Y/22/21/PL

North Barn, Hoe Lane, Flansham, PO22 8NT

Change of use from existing open barn to 1 No. dwelling (C3 Dwelling House), refurbishment & single storey extension to North elevation (renewal of permission Y/60/16/PL, amended with Y/53/19/NMA)

Drawing P02 January 2021 Scale 1:20 & 1:100 @ A3
Proposed Drawing - Site Plan & Fence Details

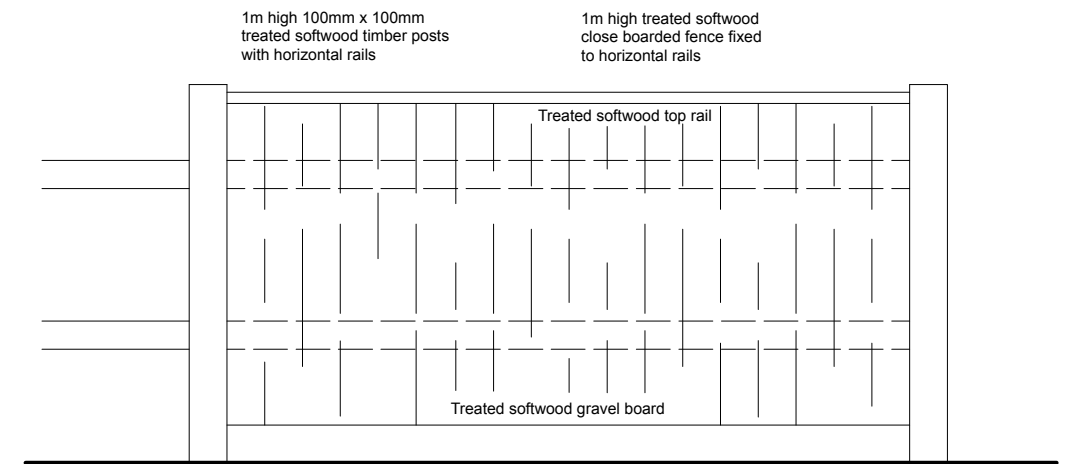
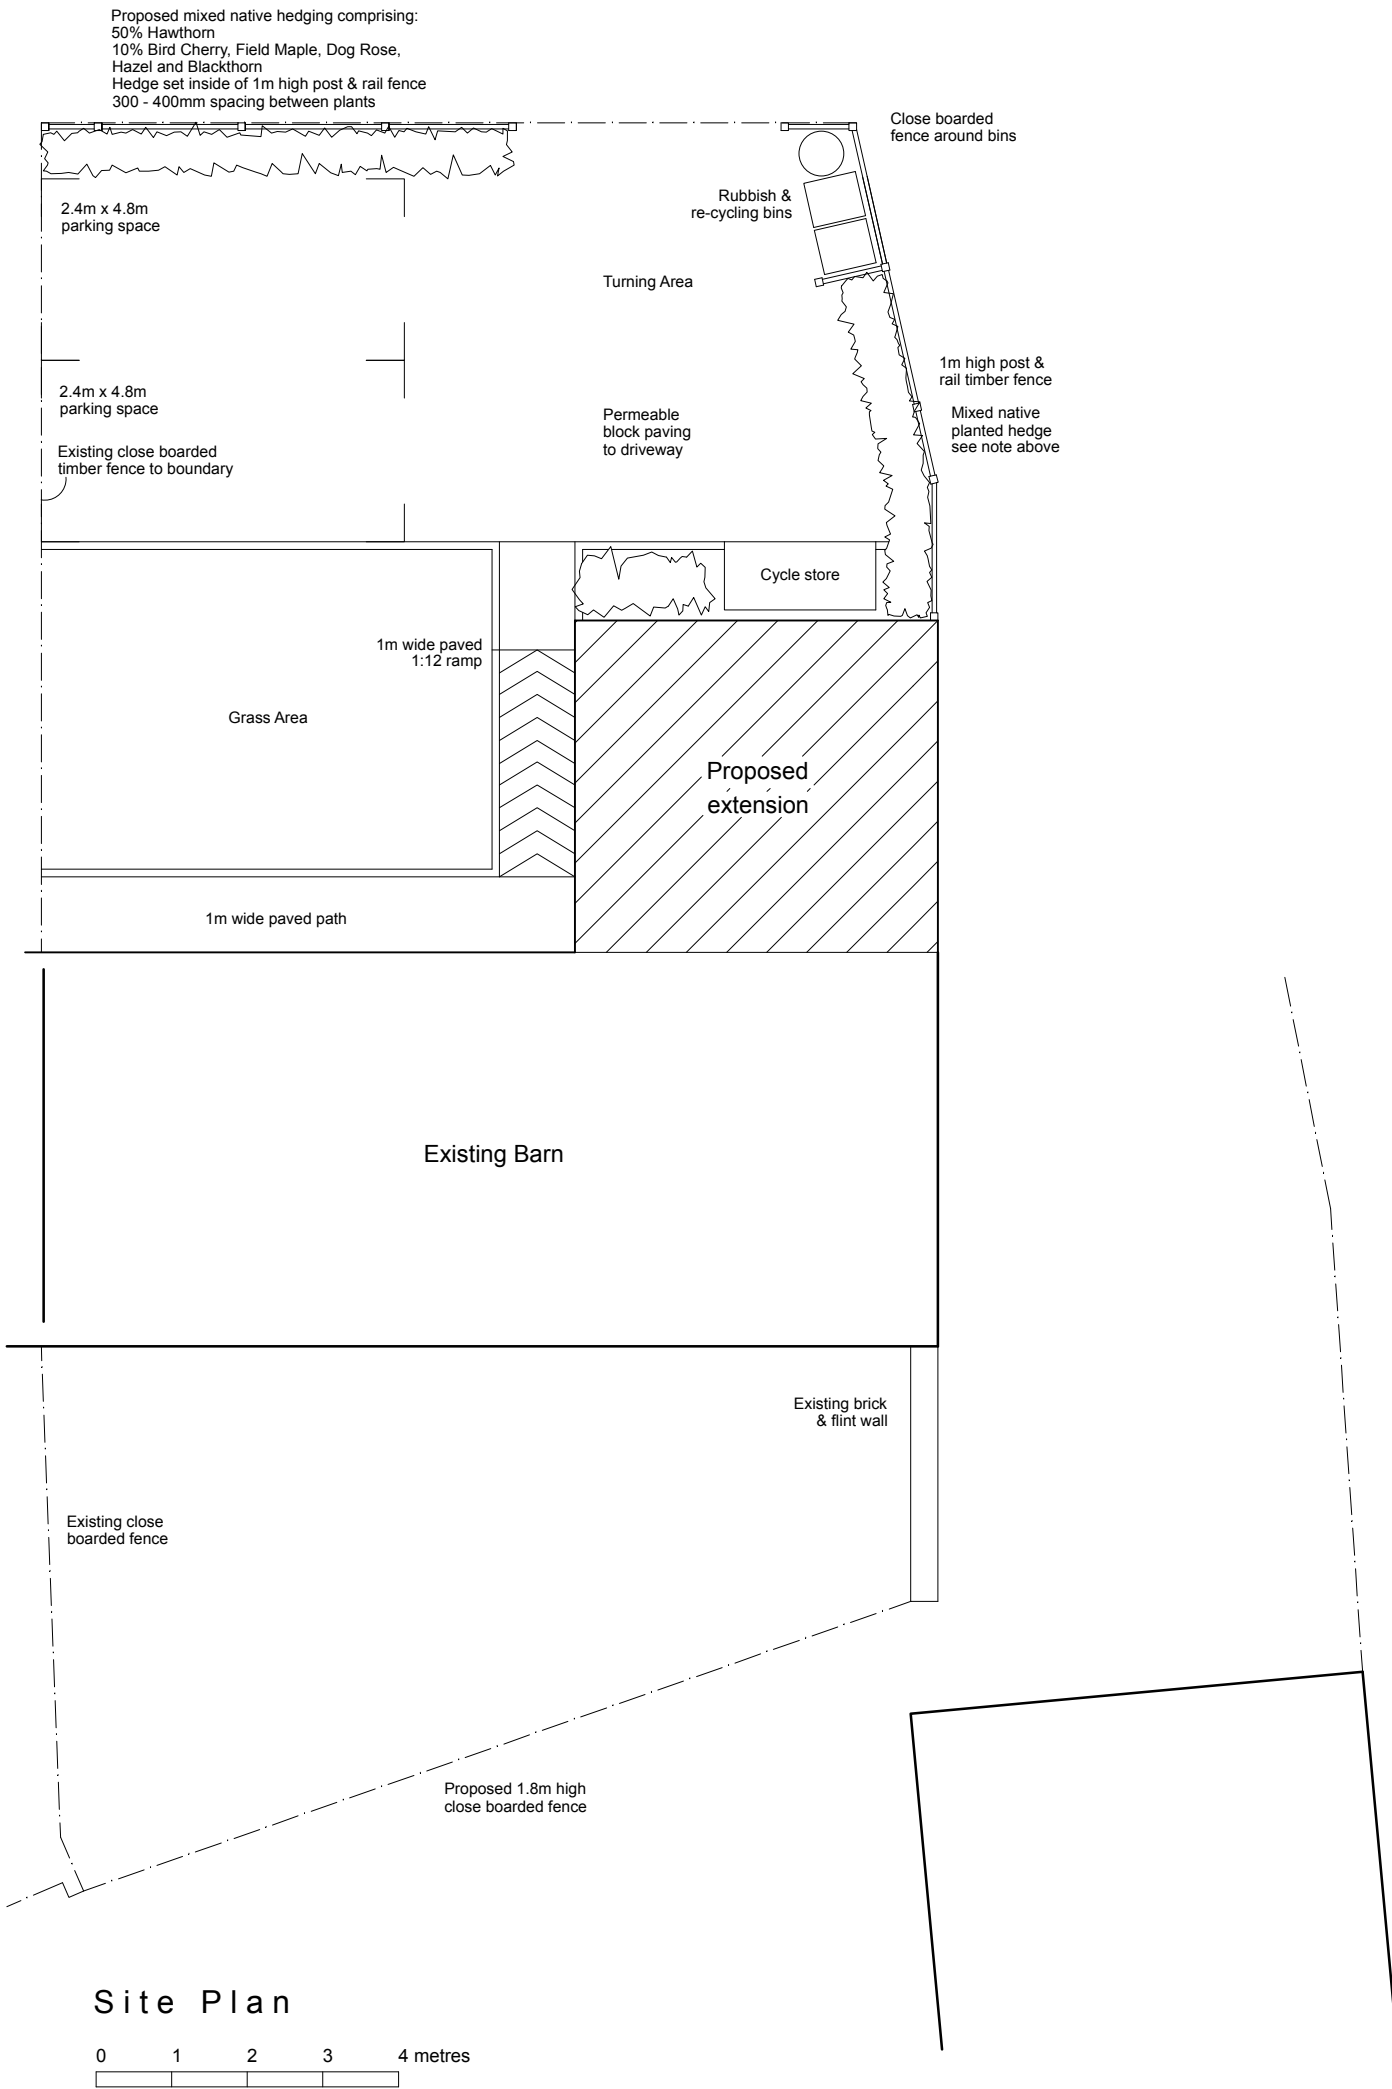
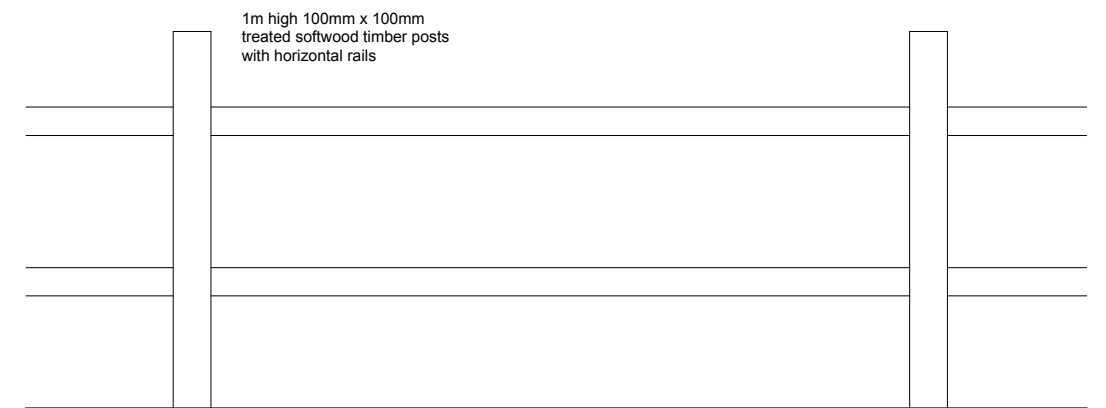
Landscaping is an essential part of any barn conversion; generally, any scheme should be simple in nature and reflect the agricultural nature of the building, as opposed to reflecting the elements found in that of a suburban house. I note that a site and fencing plan has been provided, which attempts to achieve this. A positive note is the mixed native planted hedge, whereas the proposed block paviors are more disappointing. It is thought that a more area specific surface should be considered.

Proposed Barn Conversion
at North Barn, Hoe Lane, Flansham
for Ms R Parker & Mr B Martin
Drawing P03 January 2021 Scale 1:10 & 1:20 @ A3
Proposed Drawing - Fence, Window & Rooflight Details

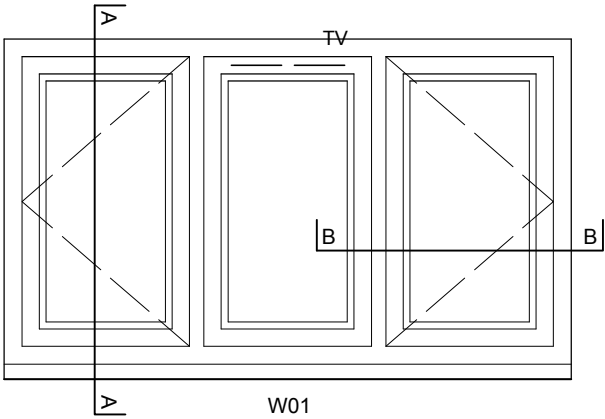
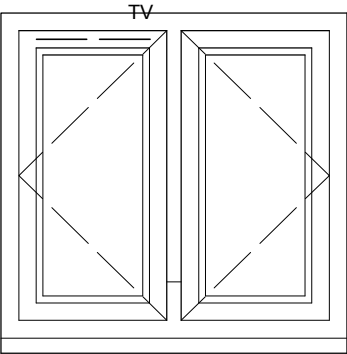
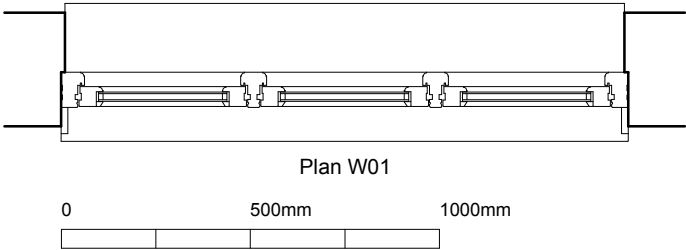
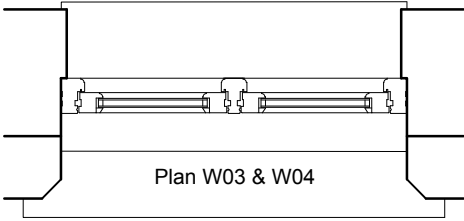
Like many farm buildings, where the historic pattern of windows is a direct product of its function, it is characterised by few external openings on certain elevations. The objective should therefore be to retain large areas of uninterrupted wall, where possible. The proposed use requires that additional window openings are introduced, but it is positive to note that every attempt has been made to limit the number required. It is noted that the window openings on the southern elevation are relatively small which results in a good amount of the attractive wall remaining intact. Further, it is noted that full use is being made of the existing large openings on the northern elevation in order to light interior spaces. This is a positive approach which helps to protect the appearance of this elevation. The design of the windows has been supplied and these seem to be acceptable,

and the fact that they are of timber construction is also supported. It would be helpful to understand how they will be treated i.e., stain or paint?

Drawing P01a November 2020 Scale 1:100 @ A3
Proposed Drawing - Floor Plan, Roof Plan & Elevations

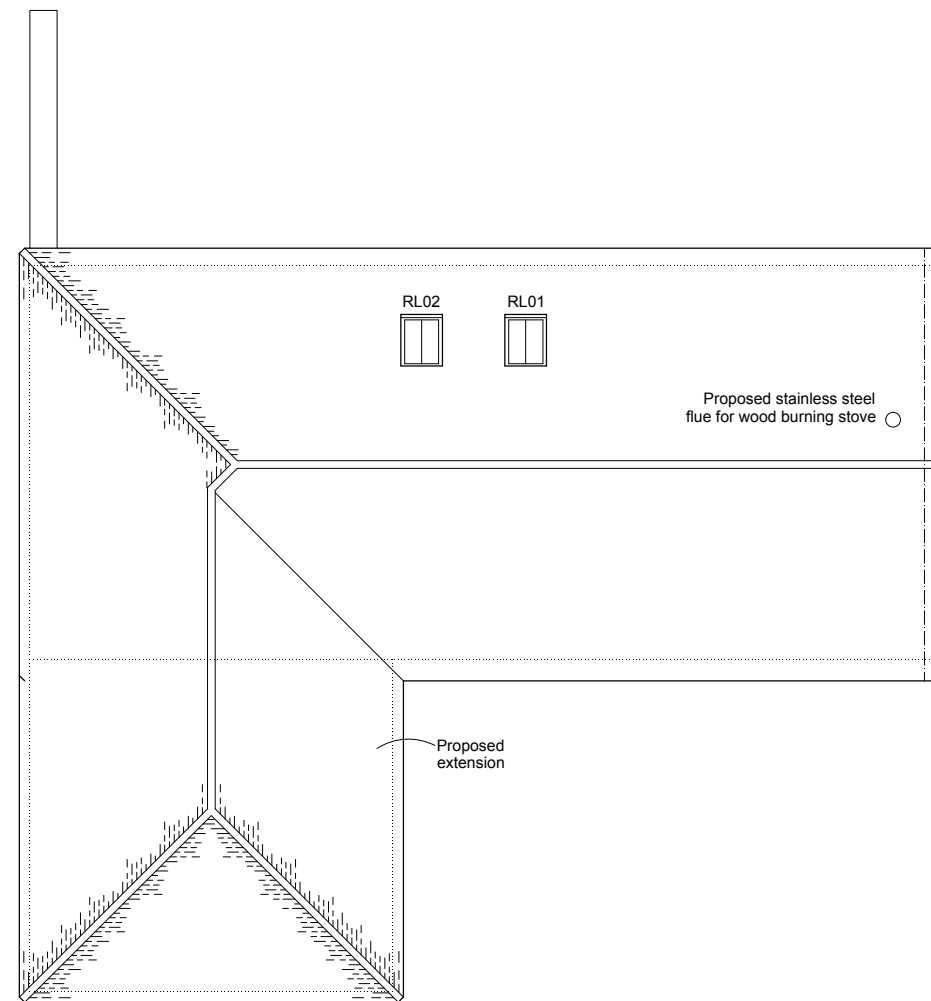
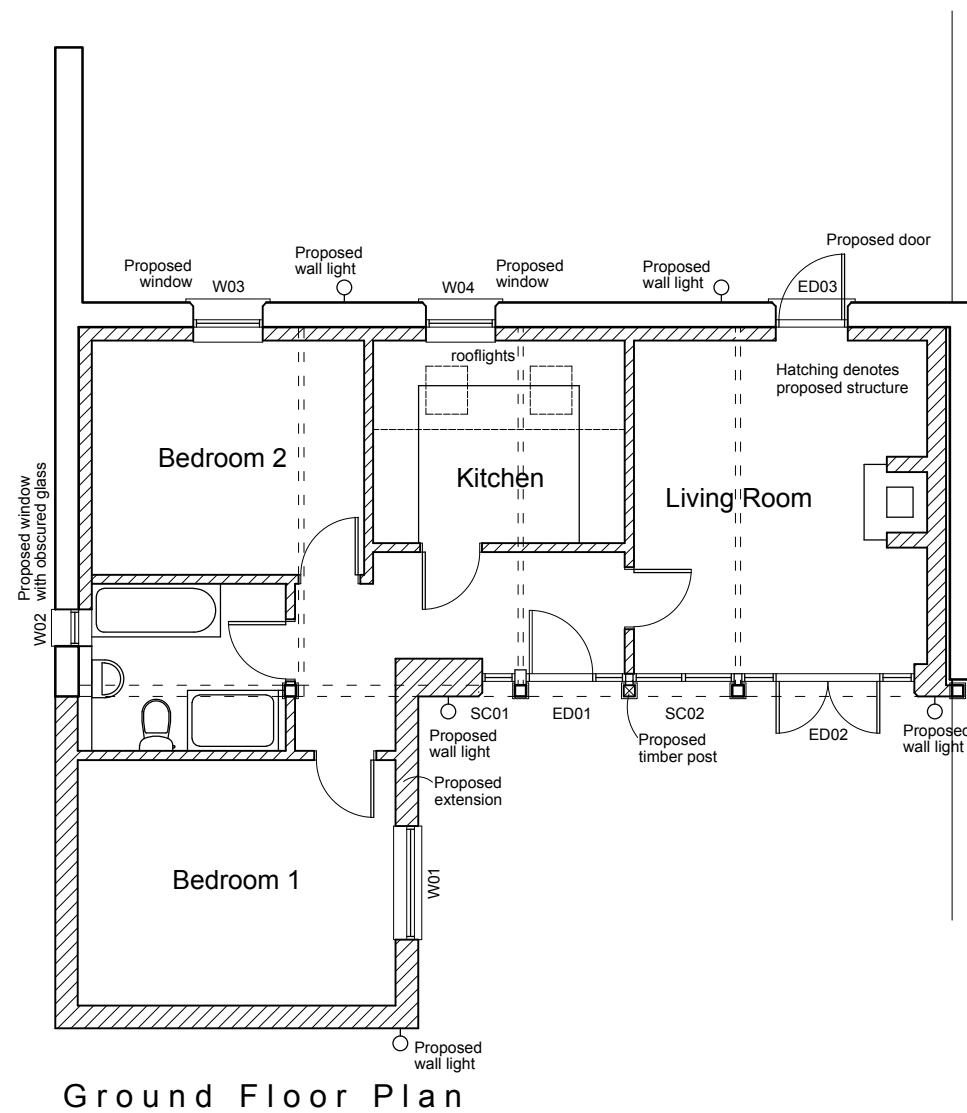
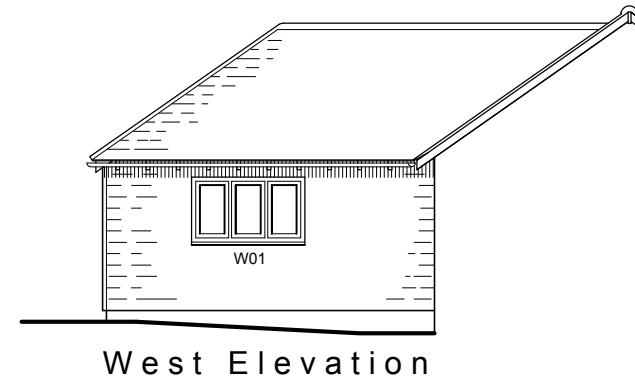
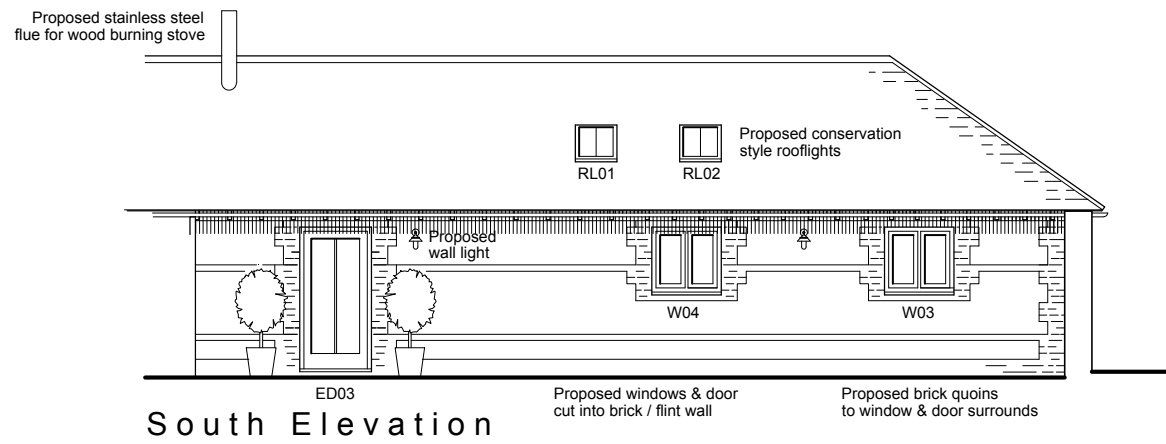
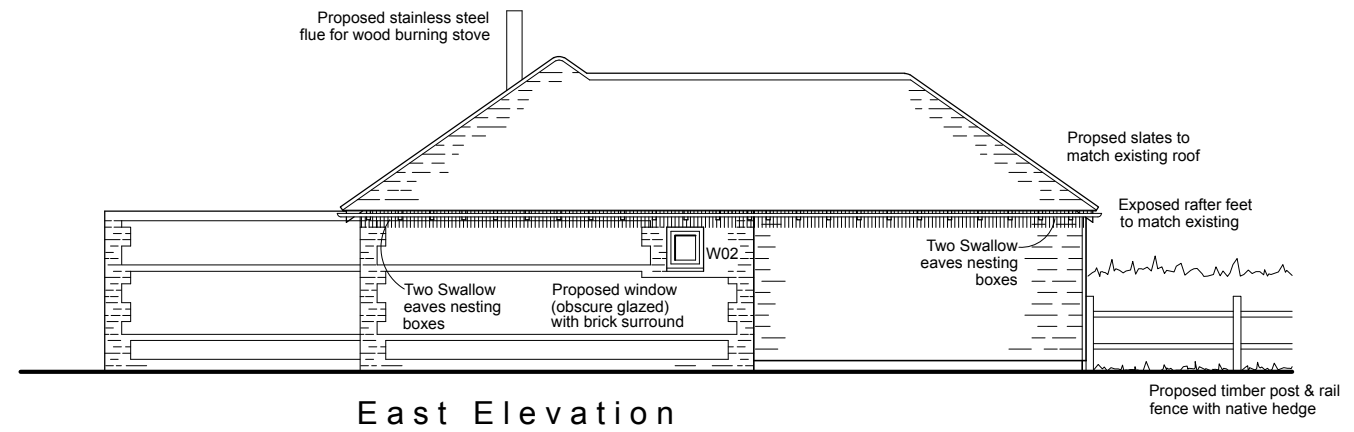
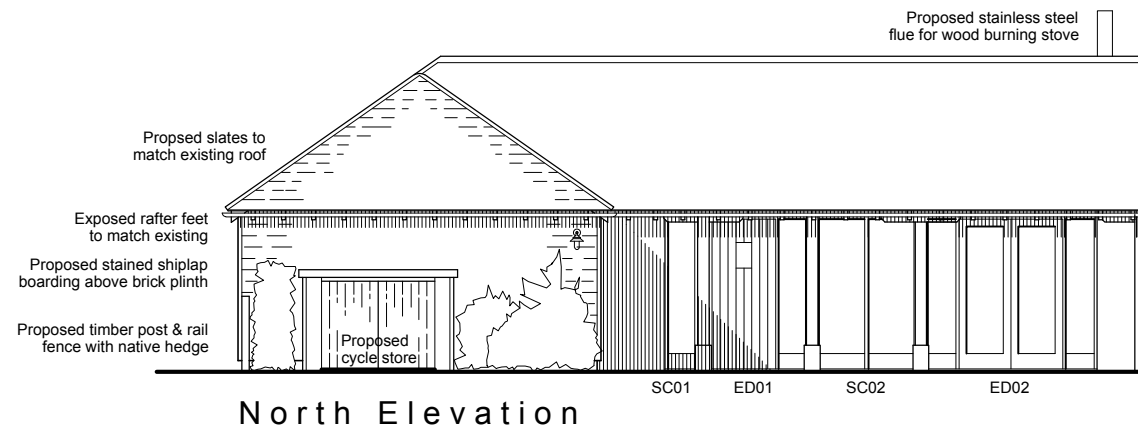
As the property currently stands, it is a small scale structure with three of the four sides enclosed. The northern elevation is currently partly open. The proposal will result in the enclosure of the open bays with windows, along with an extension on the northern elevation.

Like any agricultural buildings, the interiors are characterised by a more open space; the barn is currently divided up into two areas, which are open to the roof. Whilst it is acknowledged that the interior of the building will have to change in order to accommodate the new use, it is considered that the end use should be planned to suit the form and special potential of the building. At the moment, this open sense of space fails to survive the proposed conversion. The conversion 'carves' up the structure into a number of smaller spaces so that the proposed layout reads as a more standard bungalow as opposed to a more traditional, barn structure. Whilst the roof is of much more modern construction, it is suggested that the open roof space should be incorporated into any such proposal. As currently prepared, it is not clear how the internal roof spaces will be treated. This is unfortunate, and potentially compromises the character of the building.
